CITY OF ALBUQUERQUE

**Re: Albuquerque Retirement Residence, 8301 Palomas NE,
(D-19/D025)**

**Re: Albuquerque Retirement Residence Grading and Drainage Plan
Engineer's Stamp dated 4-10-07 (D19/D25)**

Re: Albuquerque Retirement Residence, Lots 19-22 Block 21 Tract A
Grading and Drainage Plan
Engineer's Stamp dated 12-13-06 (D19/D25)

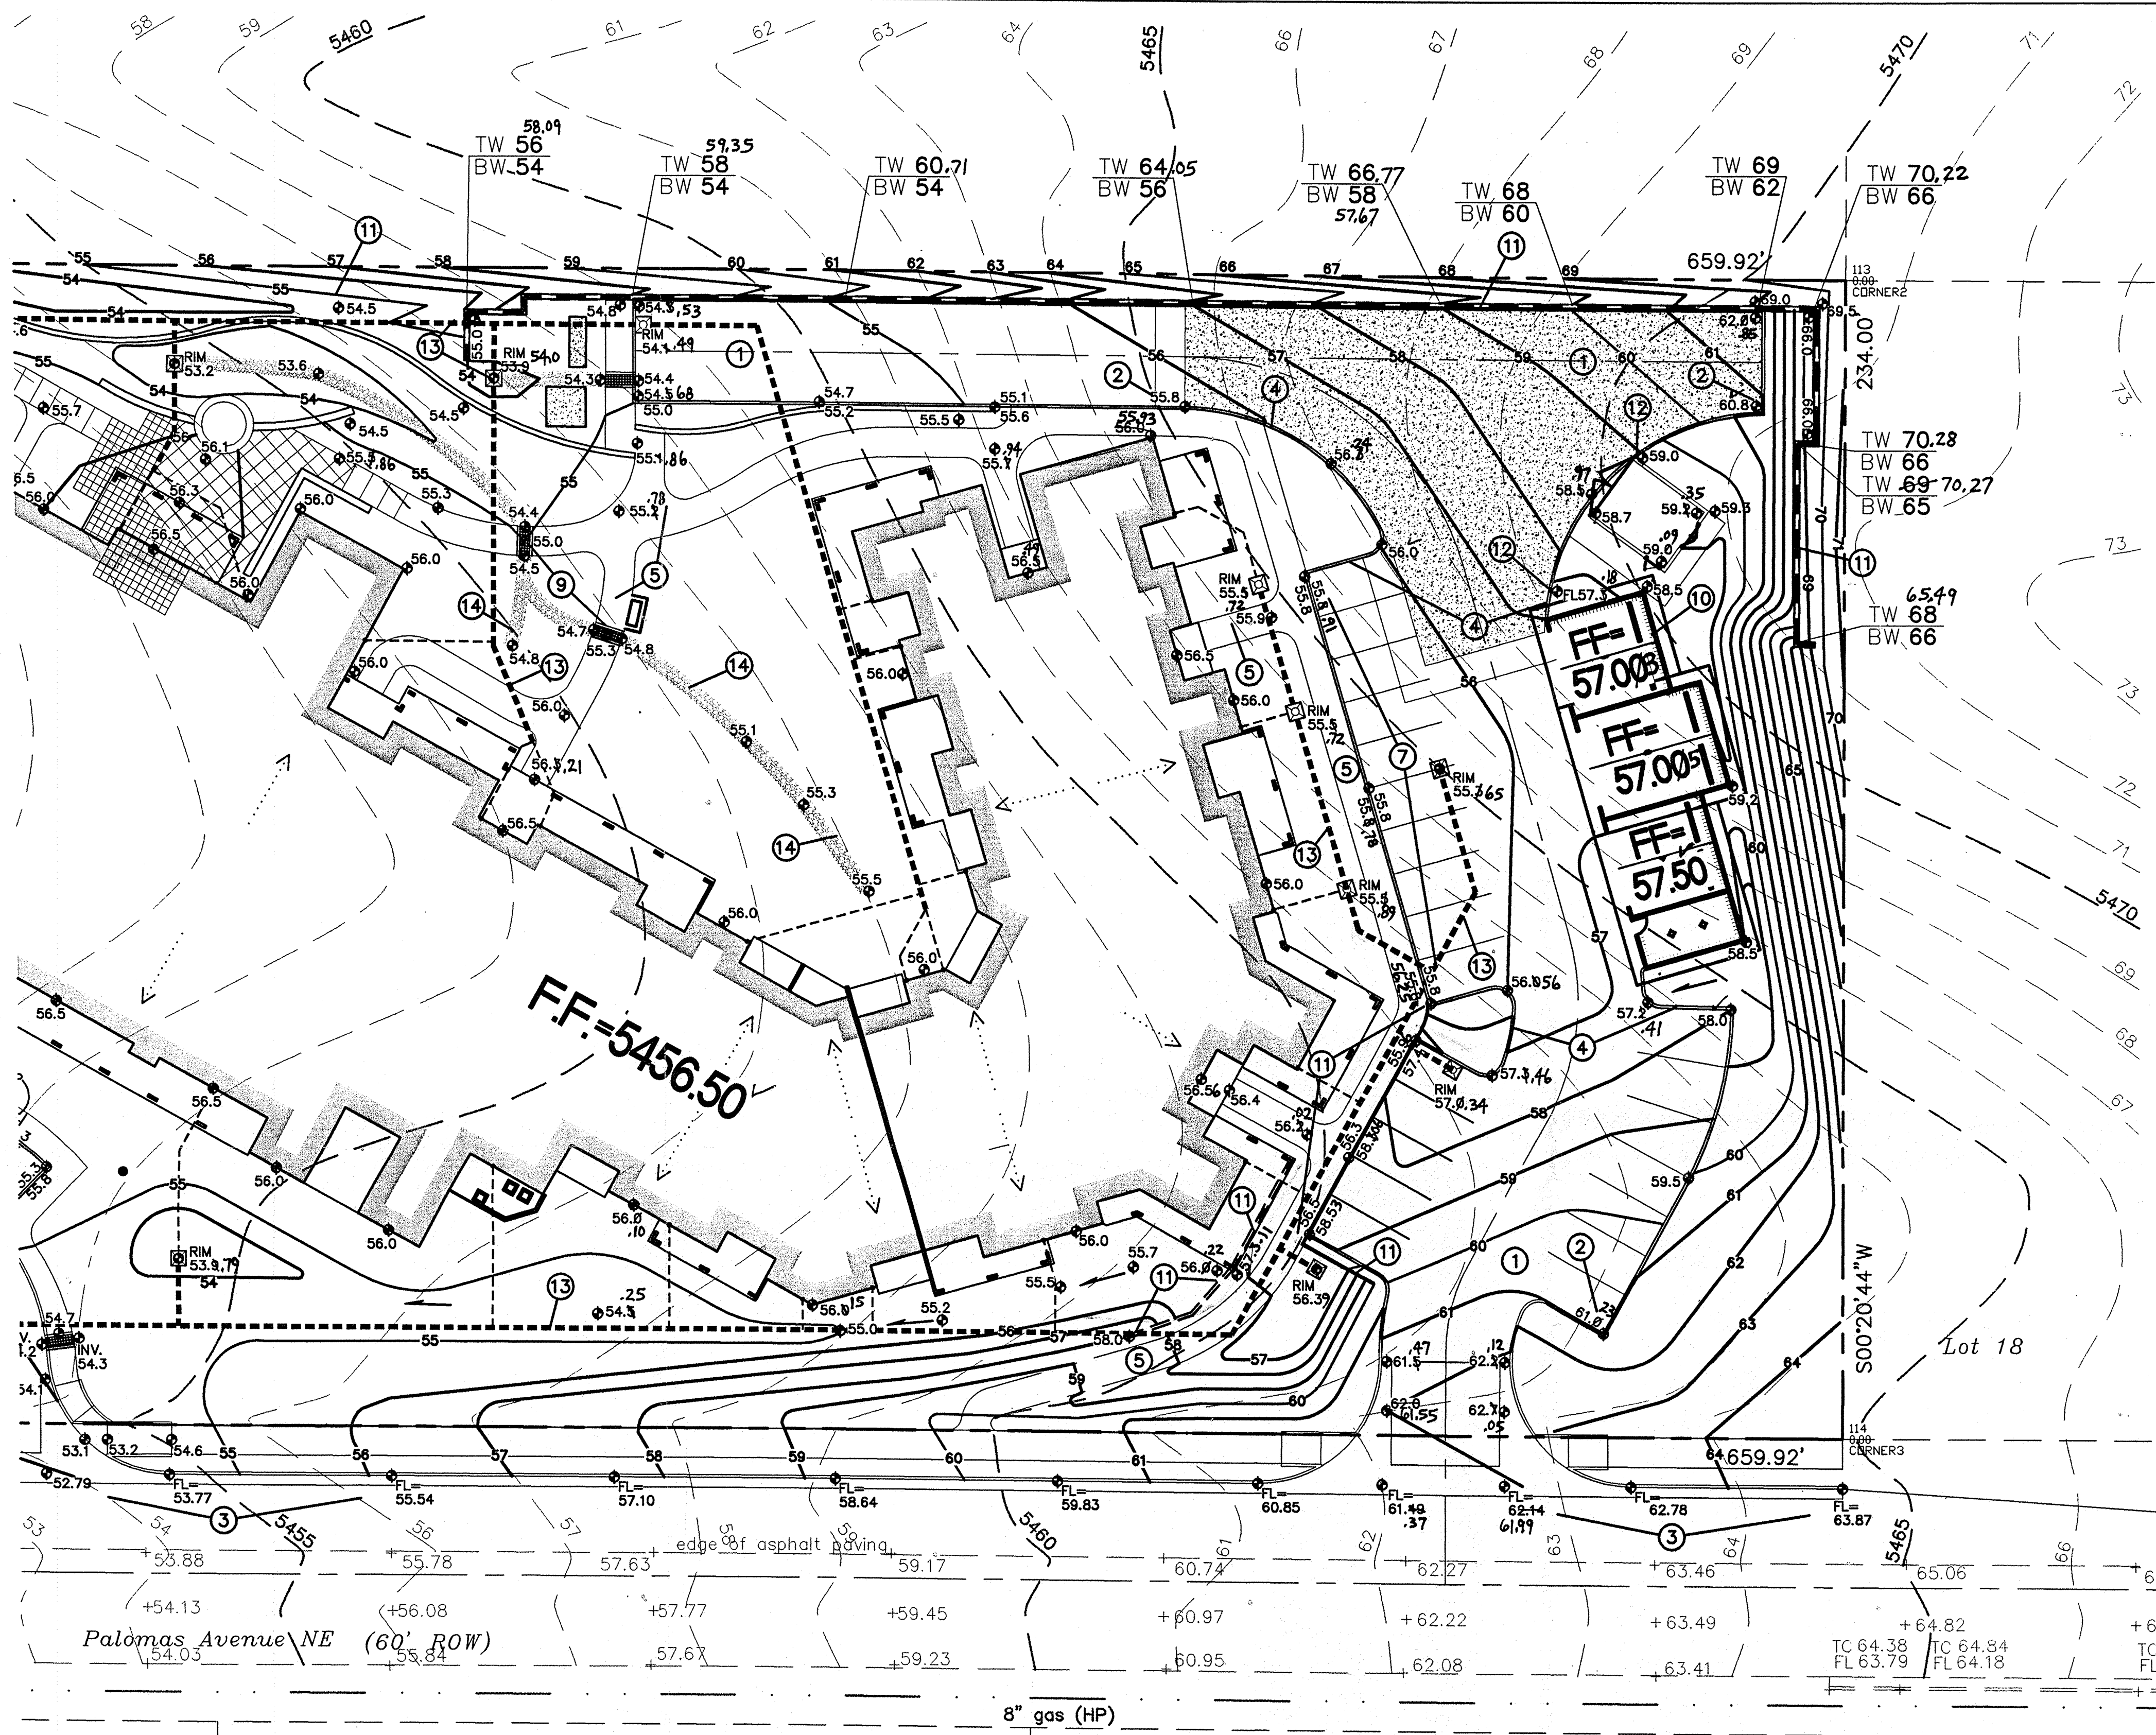
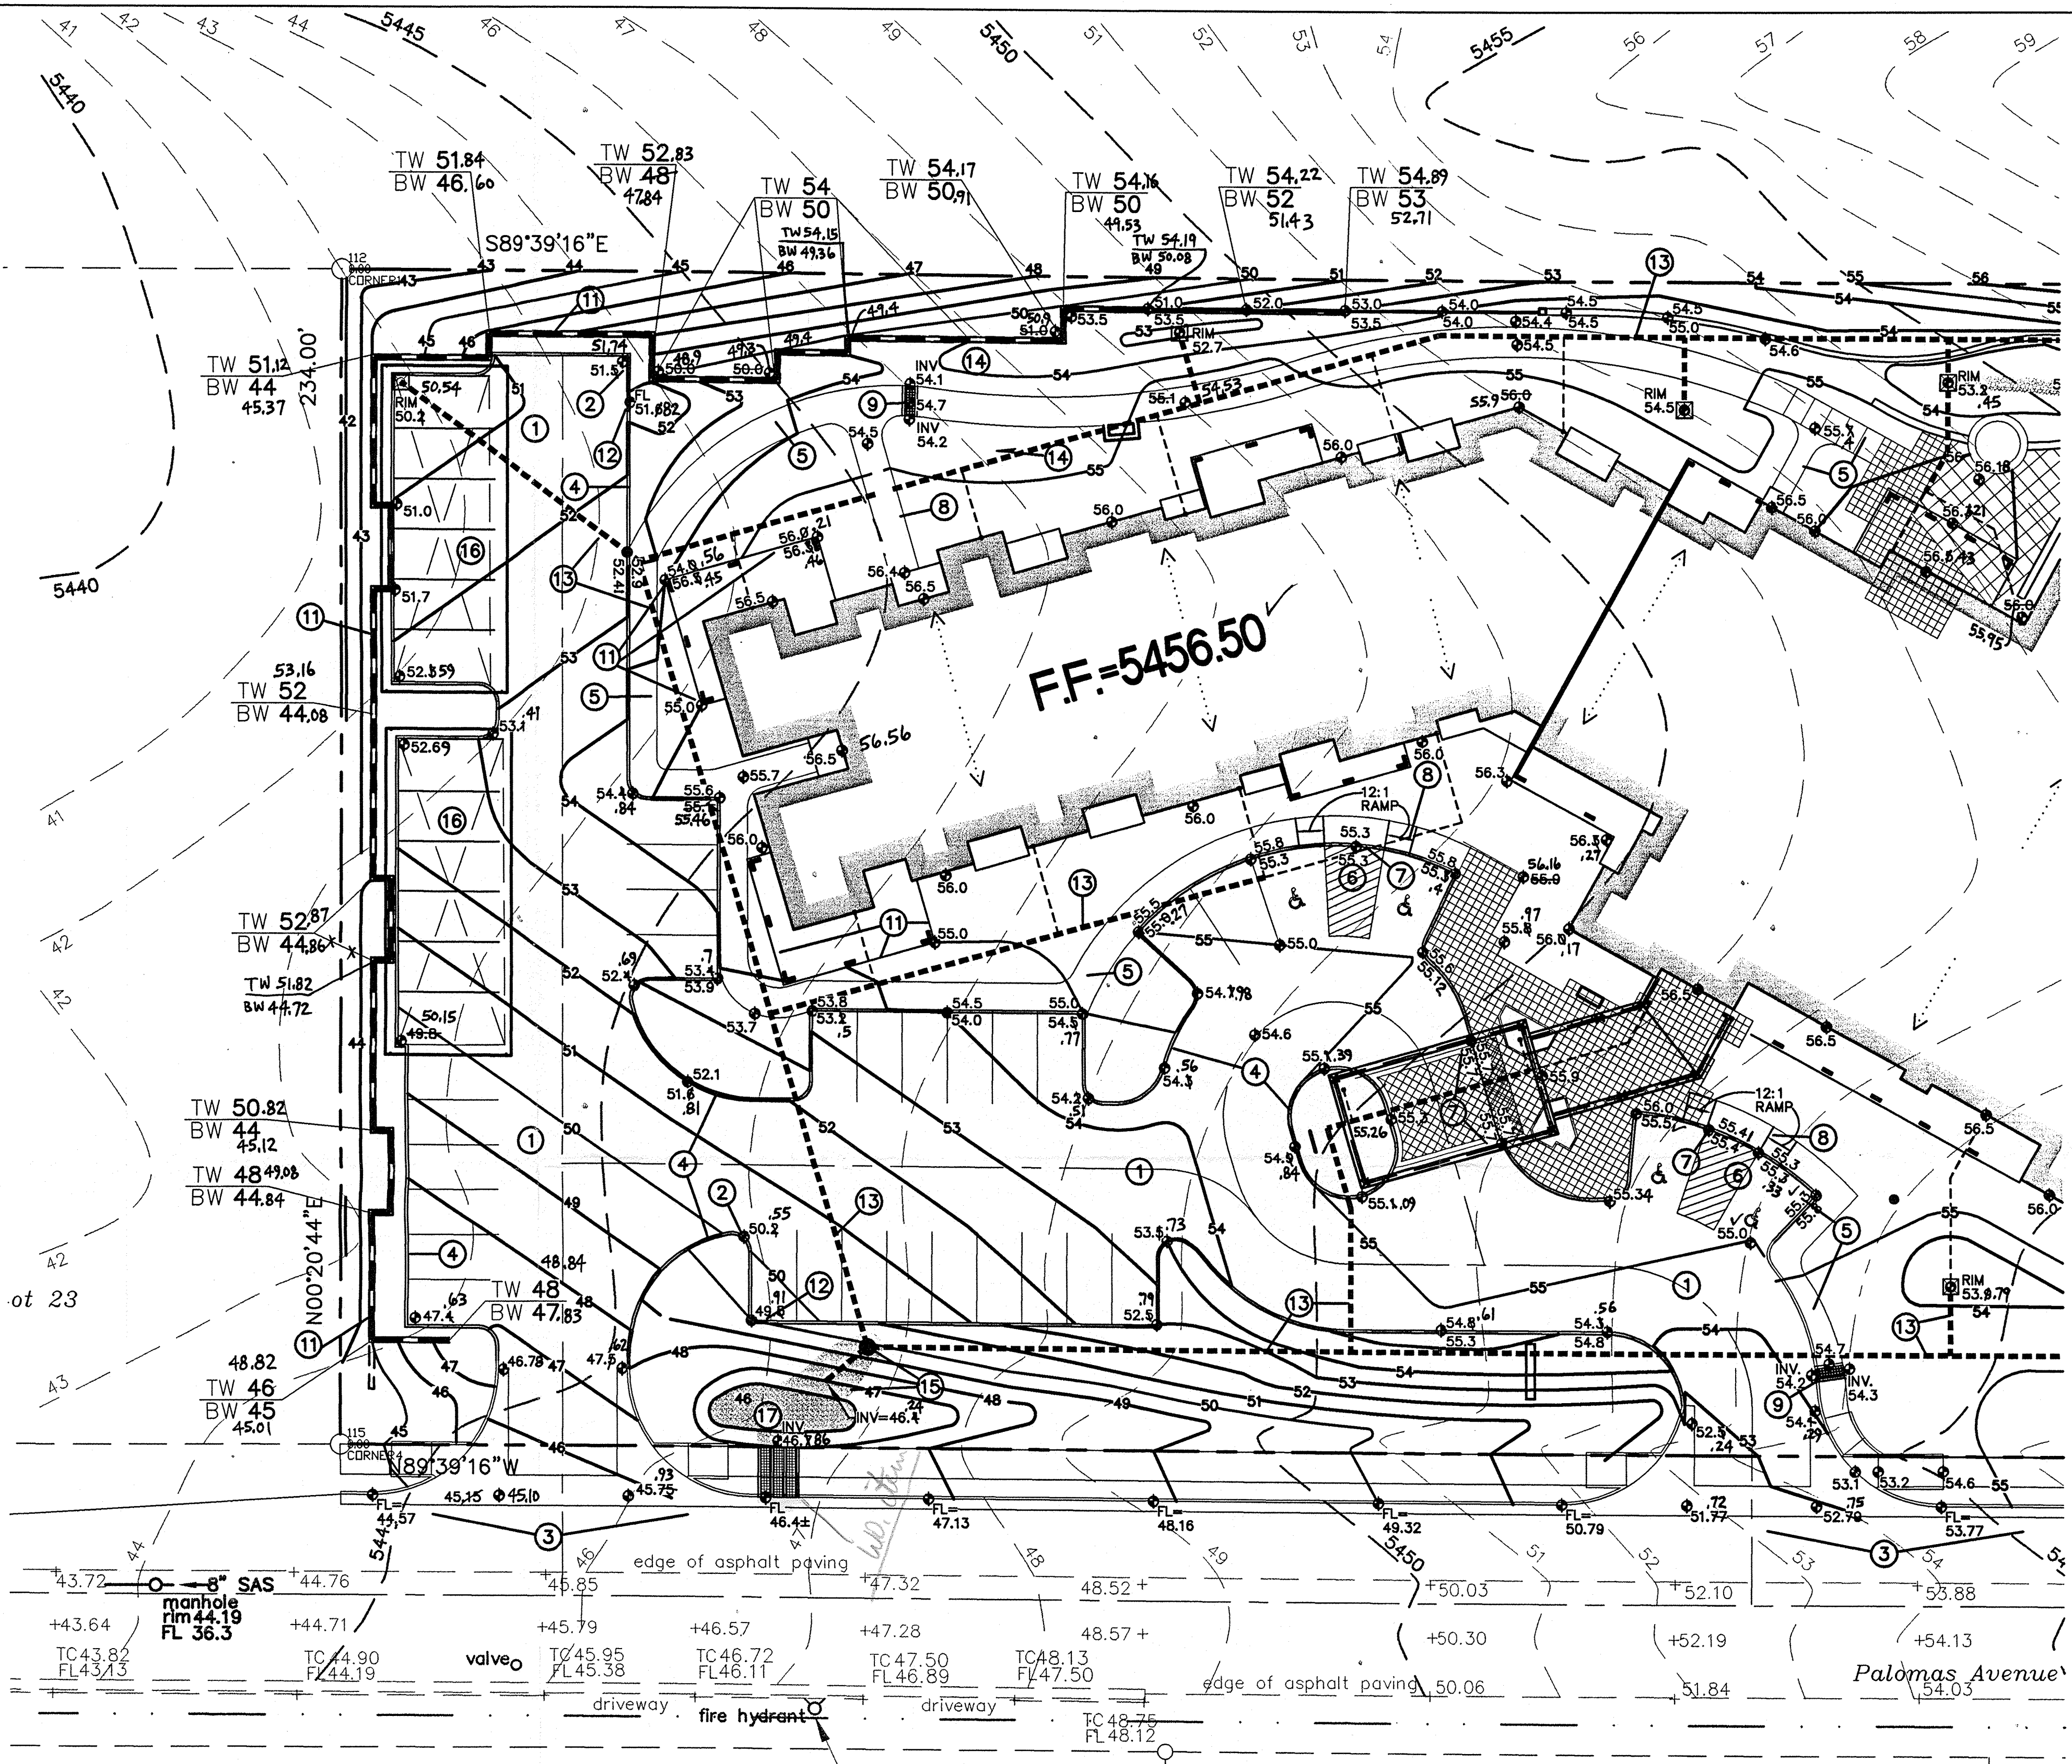
- The slope on the east side of the property that has a slope greater than 3:1 requires an engineer specified means of erosion control. Indicate method used upon certification.
- Engineer Certification per the DPM checklist will be required.
